Our ref: DOC20/697329

Your ref: SSI-9371

Exhibition of the Inland Rail North Star to NSW/Queensland Border Environmental Impact Statement

Inland Rail North Star to NSW/Queensland Border – Environmental Impact Statement

FIGURE 11.3E FIELD VERIFIED PCTS AND BAM PLOT LOCATIONS

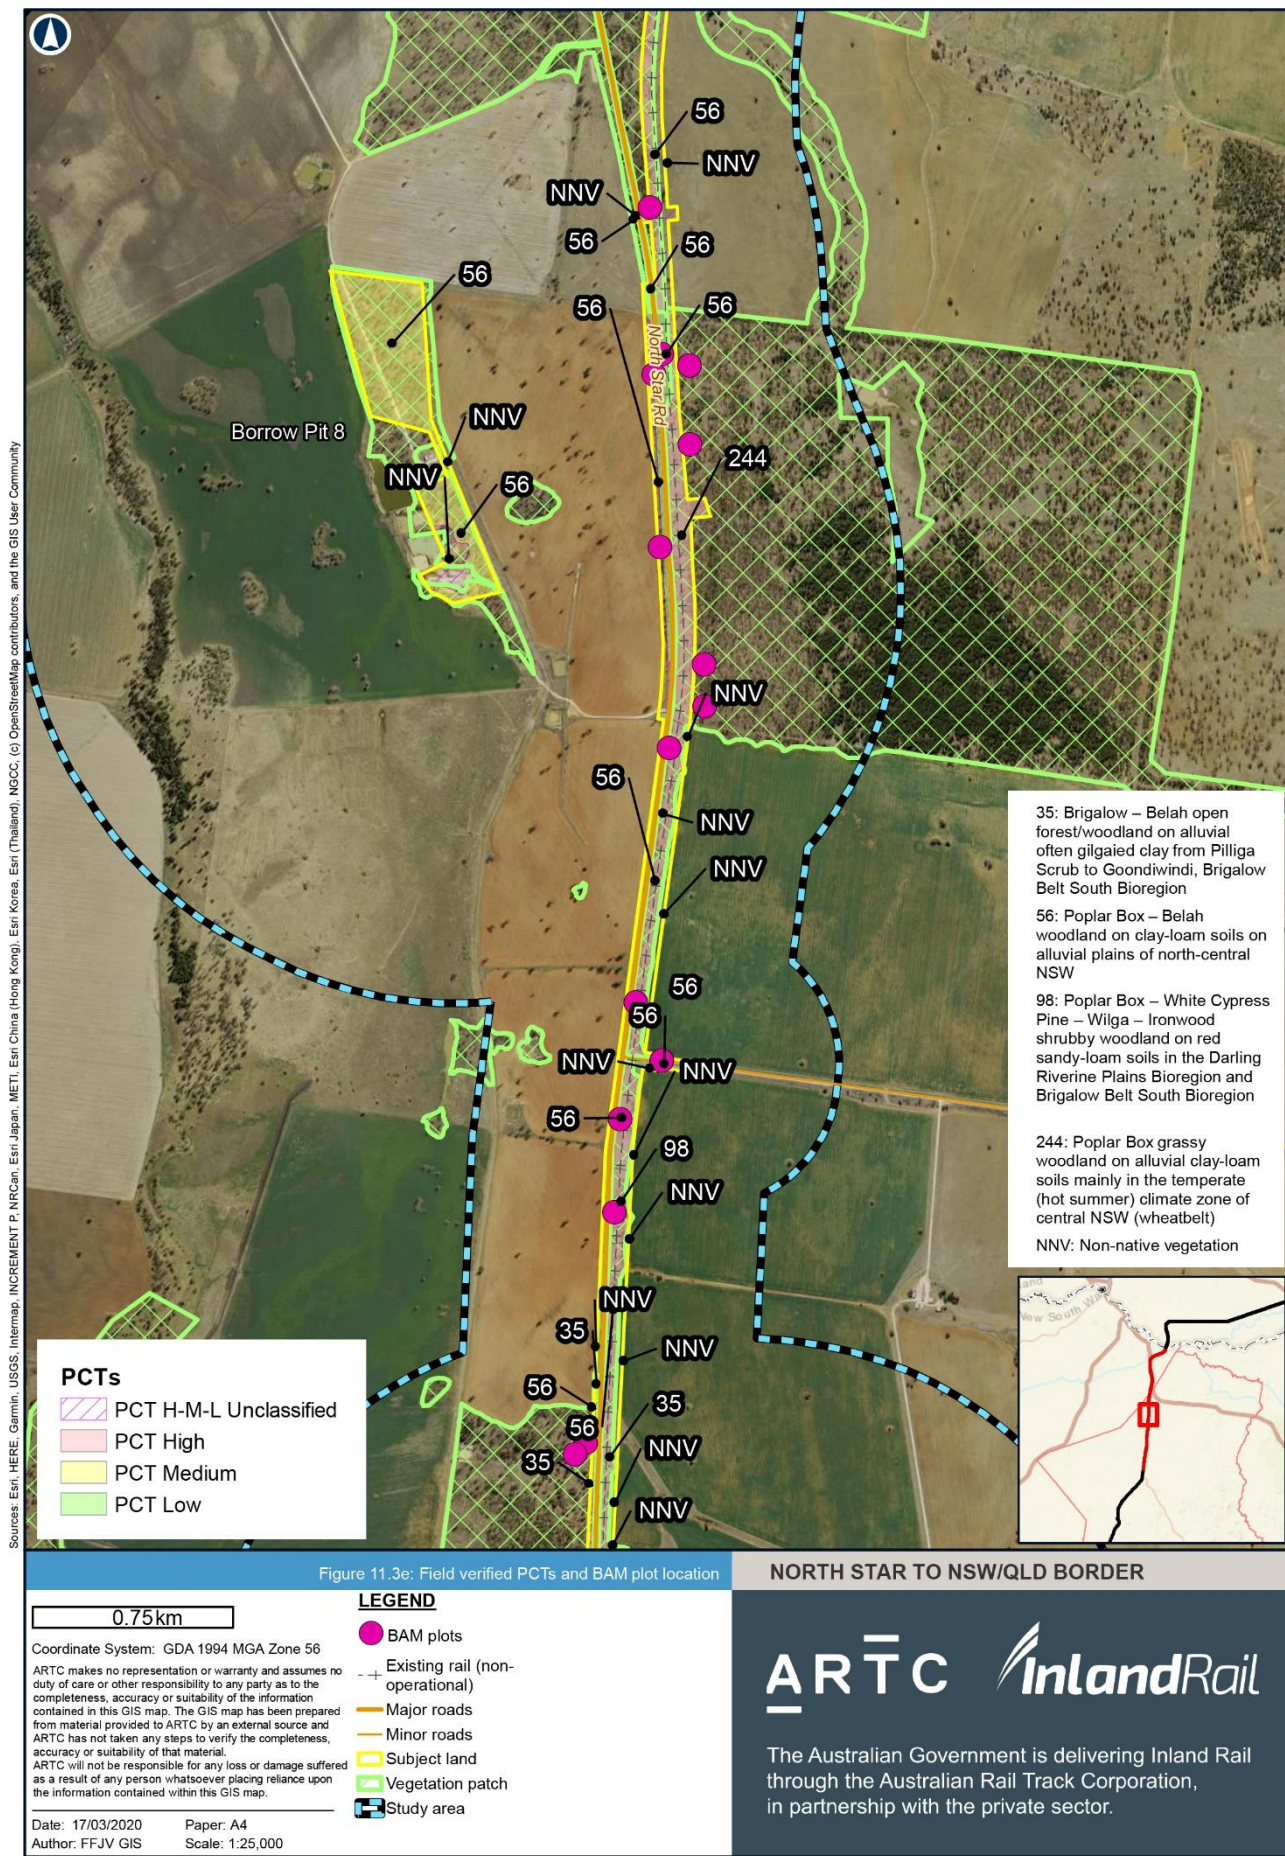
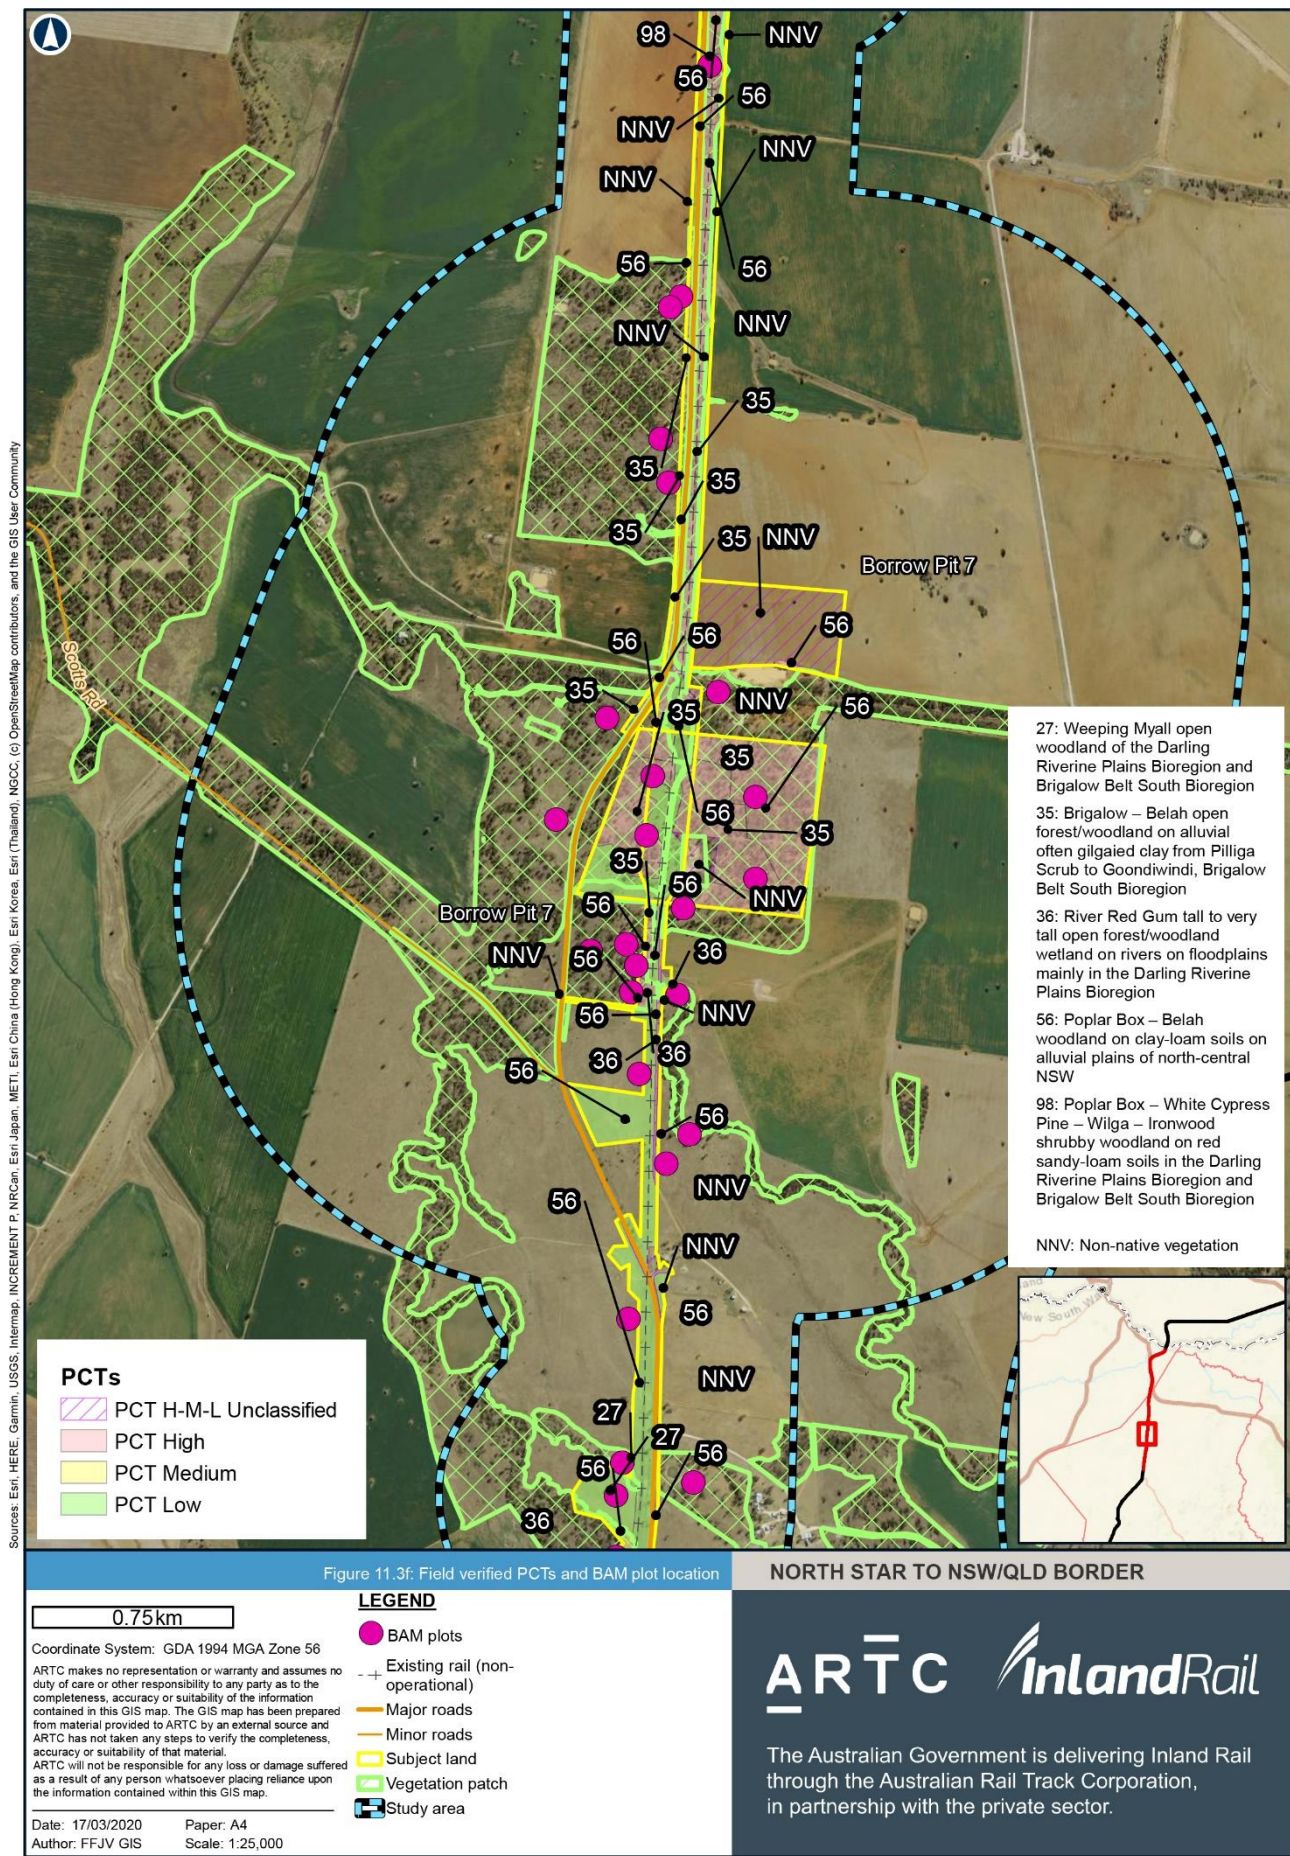
- 21.1 Explain why there are multiple sets of data for the same Plot ID.
- 22.1 The location of all plots should be reviewed to ensure that they conform to BAM. Where relevant, justification should be included in the BDAR to explain the selection of transect locations.

- 23.1 Information entered in the BAM for plots Z5P1 and Z5P2 should be reviewed, and the validity of using plot BP1LowP1 should be reviewed.
- 24.1 Review vegetation mapping to ensure that it correctly reflects the plot data collected.
